City of Albuquerque Stormwater Construction Site Inspection Report

| ESC File No. | C12E003B8 | Project Name: | Fountain Hills Assisted Living |
| NPDES Id. No. | NMR1002DD | Location: | 4551 Vista Fuente Rd. NW |

EROSION AND SEDIMENT CONTROL PLAN

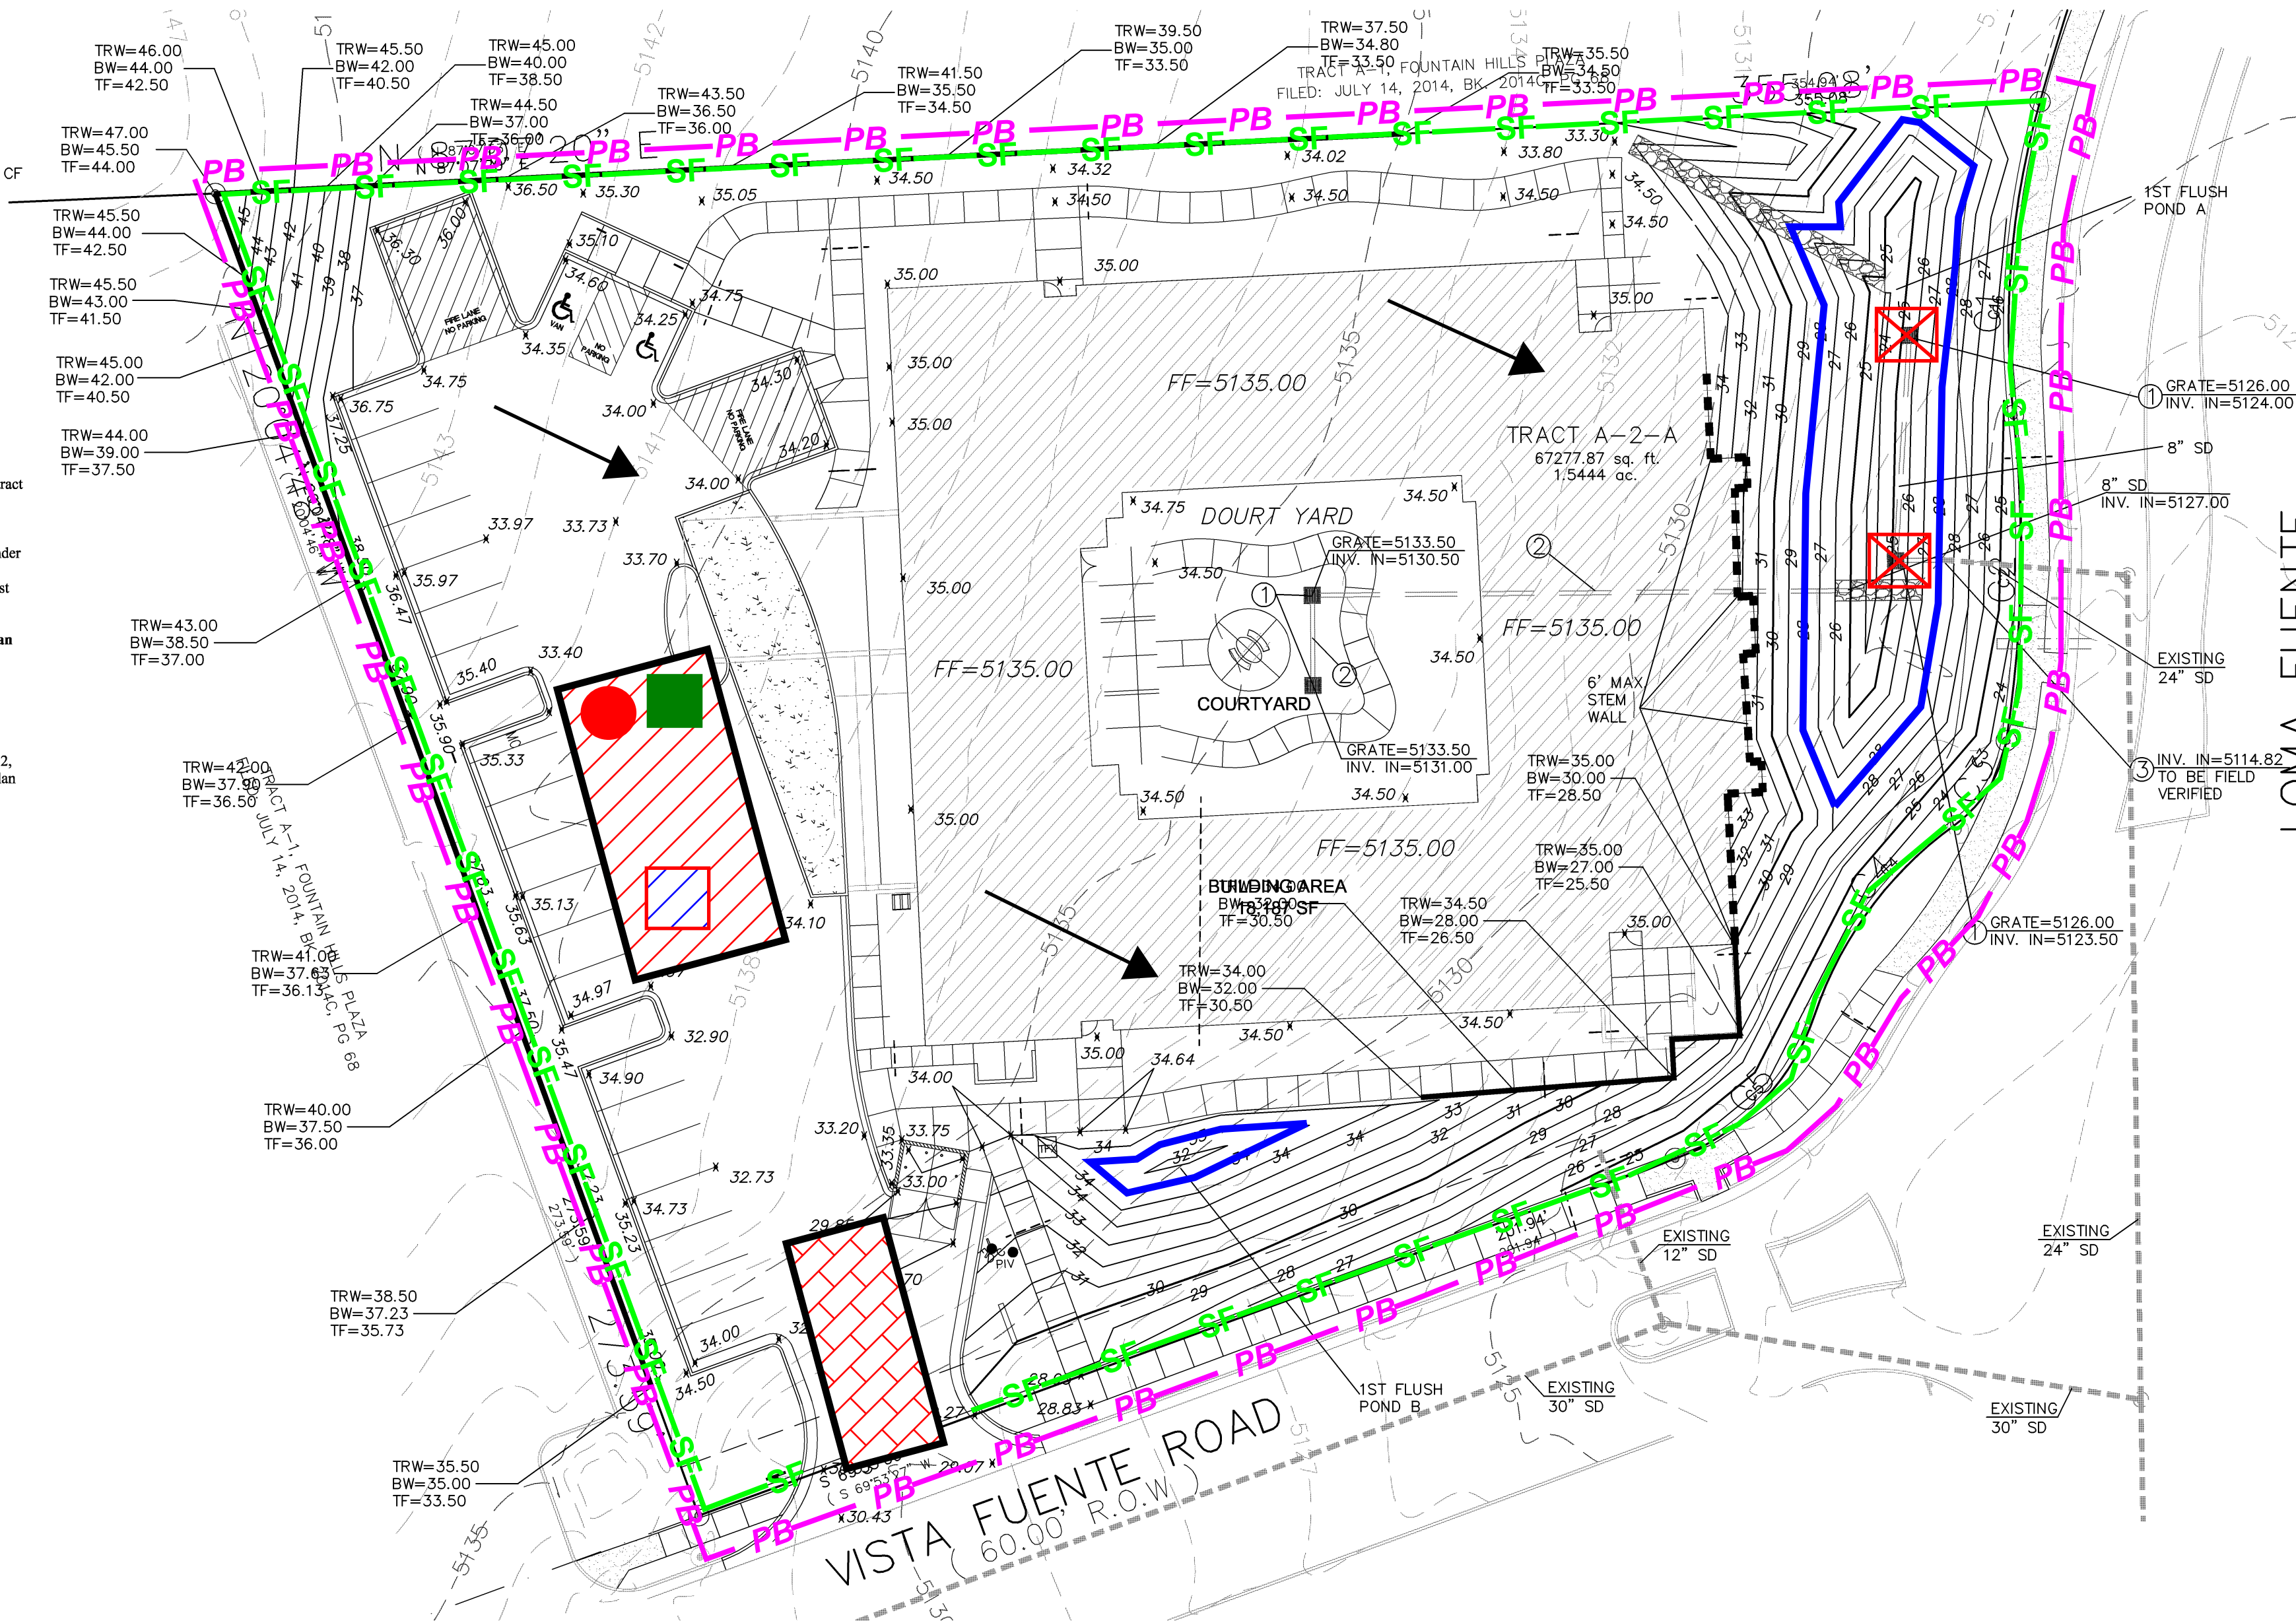
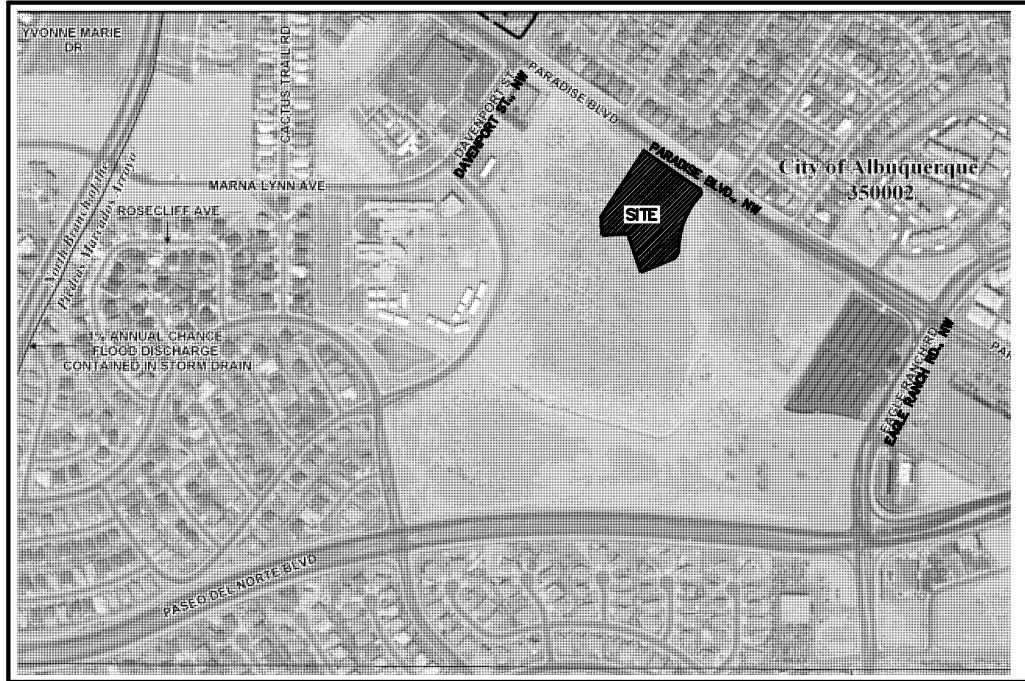
| ESC File No. | C12E003B8 | Project Name: | Fountain Hills Assisted Living |
|---|---|--|---|
| 1 | Silt fence in need of repair. Repair/replace silt fence and maintain all erosion and sediment controls. Install sediment control BMPs on East side of the site at the sidewalks. | | |
| 2 | Sediment in street. Remove trackout and sediment from the street daily. | | |
| 3 | Washout on ground. Direct wash water from concrete, paint, and stucco into a leak-proof container per CGP 2.3.4. Remove and dispose of hardened concrete with other waste in per CGP 2.2.3. | | |
| 4 | Wattle not properly protecting inlet. Reposition wattle and remove sediment from the inlet. | | |
| 5 | Construction waste on the ground. Remove and dispose of construction waste in approved waste containers (CGP 2.3.3e) | | |
